Boston Alternative Energy Facility

**Natural England's Comments on the Applicant's Deadline 1 Submissions in Relation
to Air Quality [REP1-007, REP1-021, REP1-028]**

Planning Inspectorate Reference: EN010095

11th November 2021

**BOSTON ALTERNATIVE ENERGY FACILITY DEVELOPMENT CONSENT ORDER**  
**Regulation 5(2)(o) Overview of Statutory and Non Statutory Sites**  
**and Features of Nature Conservation and Habitats Plan**  
**BOSTON BOROUGH COUNCIL - Sheet 1 of 1**

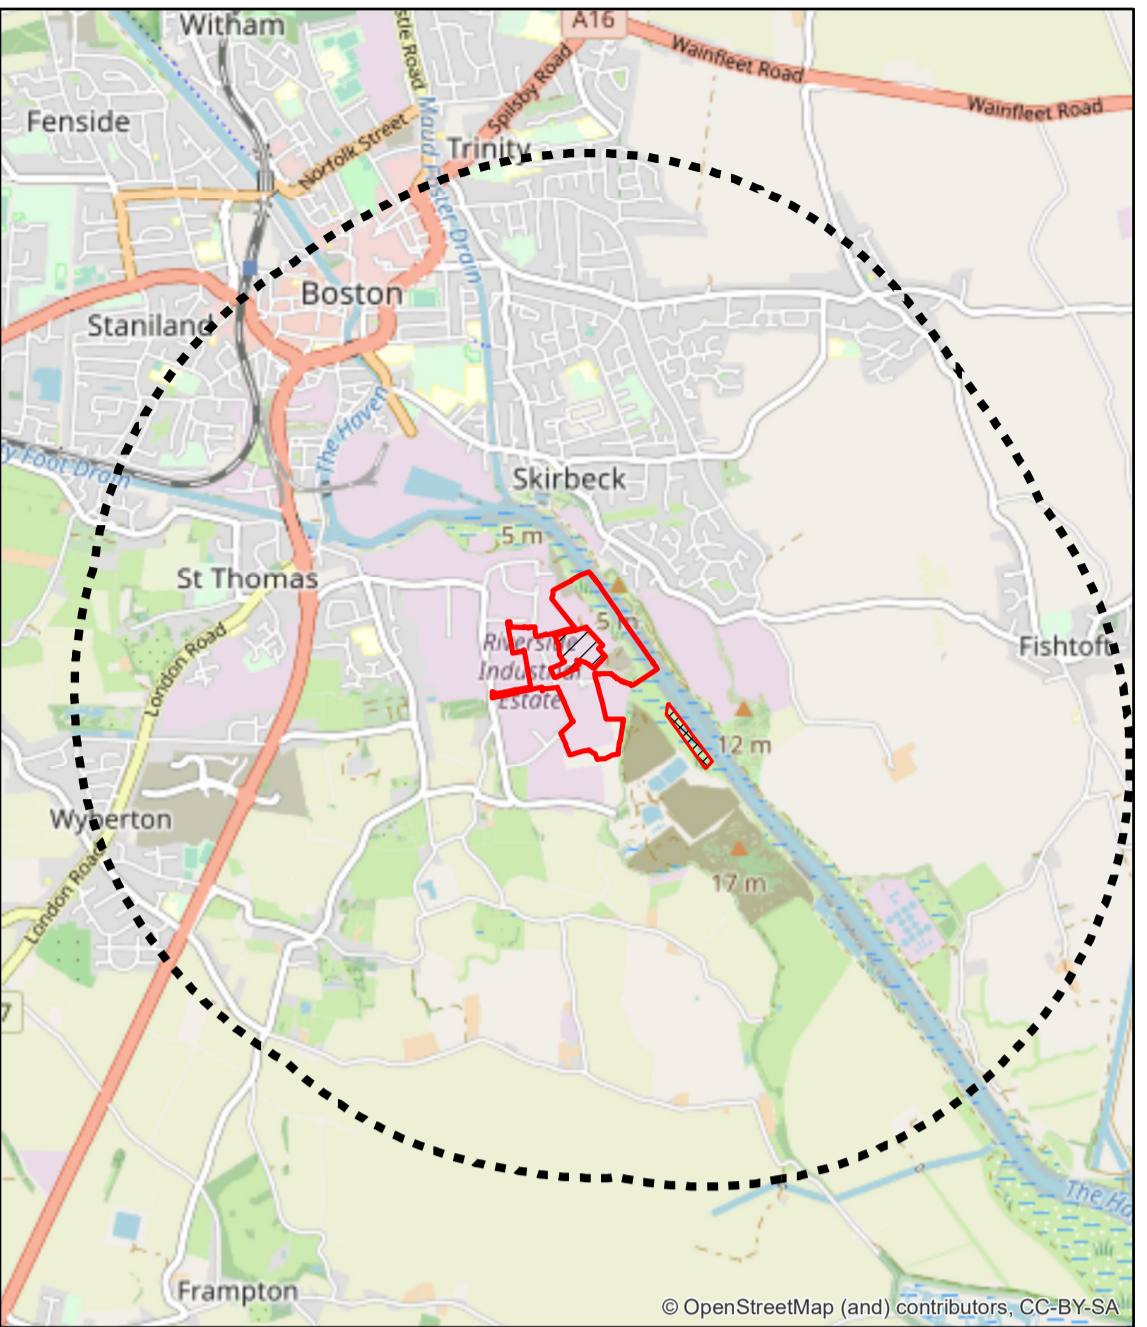
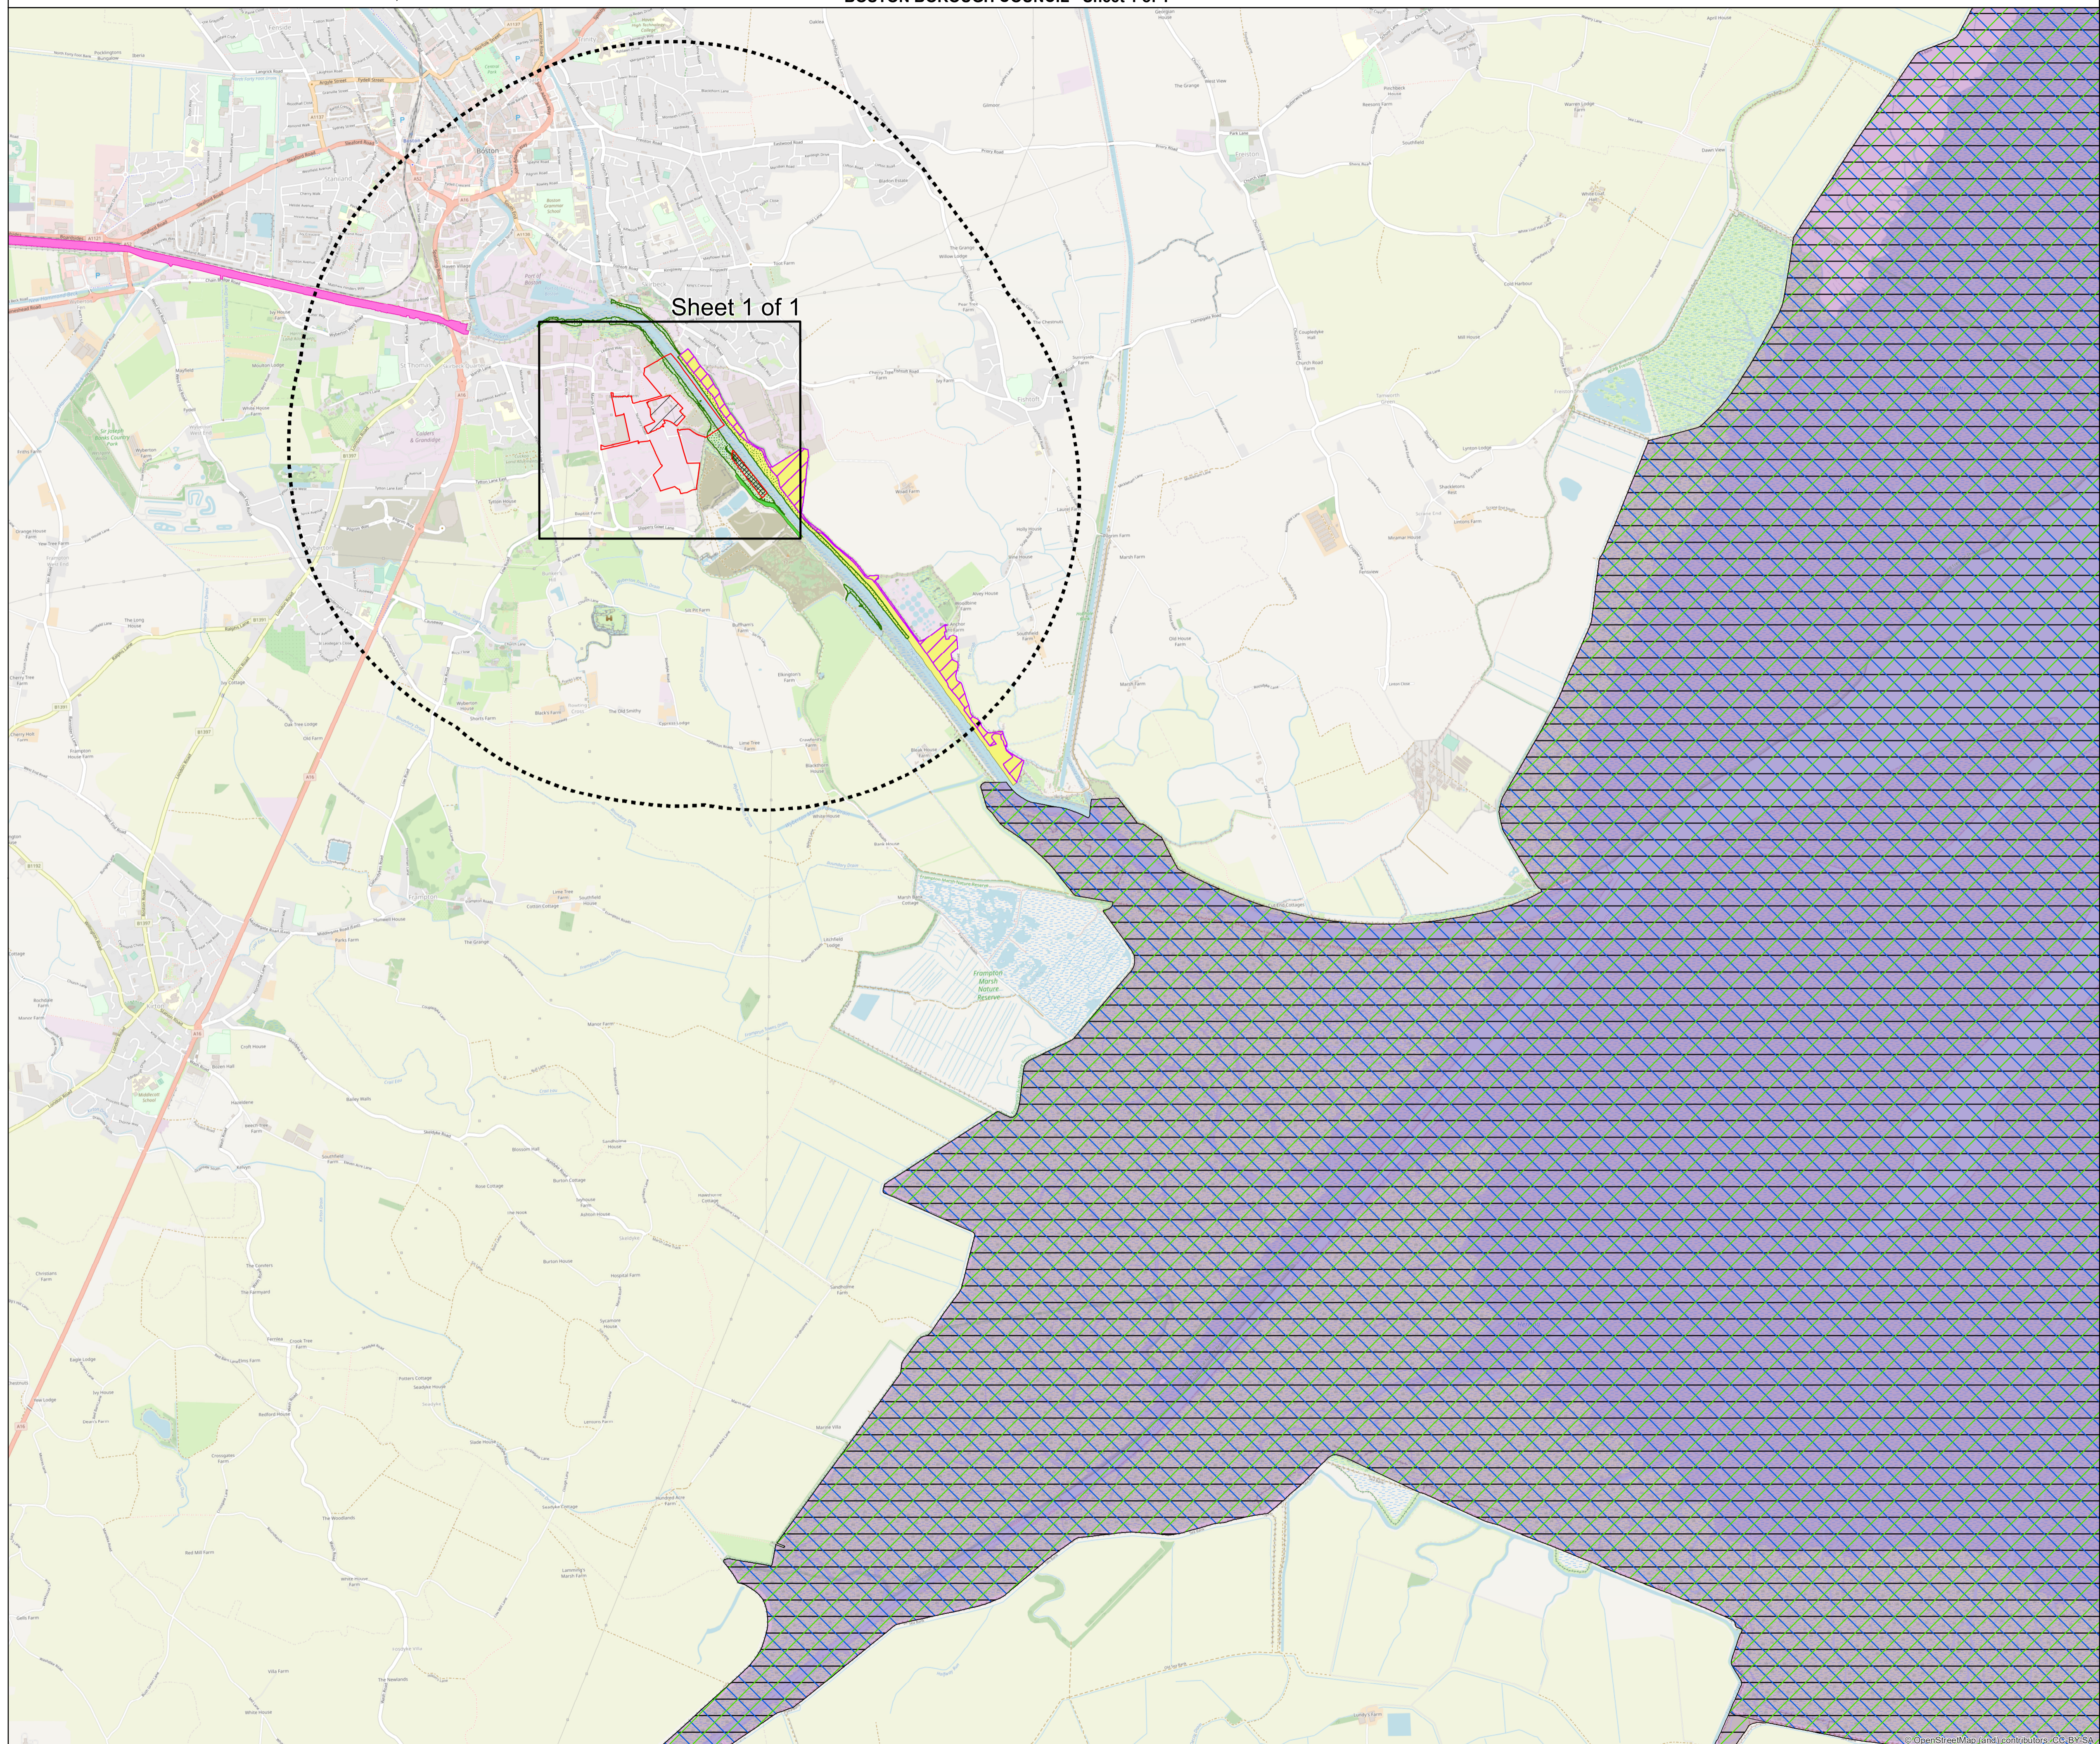
Point	Section	RR Comment	RR Recommendations	Deadline 2 update	RAG status
Chapter 14 – Air Quality					
D1.	14.4.26	Whilst dust impacts during construction considered at Havenside LNR; what about on the area of saltmarsh being used for the Habitat Mitigation Area?	Natural England advises that all areas relevant to the proposals are thoroughly considered.	Natural England notes that dust impacts during construction is mentioned in REP1-028 (Marine and Coastal Ecology Appendix 17.1). However, mitigation measures will be secured in the Code of Construction Practice. We will review this

D6.	14.4.61 17.8.240	We support the consideration of an assessment on priority saltmarsh habitat. However, are there other sensitive habitats.	Natural England requires the applicant to provide recent survey data or evidence to support this decision to only consider saltmarsh. A footprint map confirming that only saltmarsh is present within the area of impact would be beneficial.	Natural England notes that REP1-028 Table 14-10 shows that relevant habitats within the LNR and LWS have been considered, and that only saltmarsh is listed in APIS and can therefore be assessed. The APIS for Nitrogen deposition on Coastal and Floodplain Grazing Marsh states that no studies have been made of N deposition effects on these habitats, and thus no quantified effects of potential modifiers are available. It also reports that run-off from fertiliser etc is more likely to be important sources of Nitrogen; and flocks of wildfowl may increase local ammonia levels

D	14.7.55	Natural England notes that all levels of pollutants exceeded for LNR and LWS. Therefore, we query what the effects of N deposition on the Habitat Mitigation Area will be? If based on similar values to Havenside LNR then PEC predicted to be marginally over the most stringent critical load range (20-30 kg N ha ⁻¹ year ⁻¹).	Natural England advises that all areas relevant to the proposals are thoroughly considered.	Natural England welcomes the inclusion of data for proposed Habitat Mitigation Area (and additional areas of saltmarsh on both banks) in REP1-007 (Chapter 14 – Air Quality) Table 14-35, Therefore, this matter is resolved.	
D	14.8.9	Paragraph states - The Facility was not predicted to lead to any significant effects during its operation which would require mitigation measures. As the Facility would be required to operate under the conditions of its Environmental Permit, this is	Natural England advises that further clarity on how impacts to designated sites will be mitigated and any measures secured.	Natural England notes that REP1-007 states mitigation measures will be secured in the Code of Construction Practice. NE will review this document once it has been submitted into examination. However, we advise that the CoCP will need to consider in-combination phase impacts during
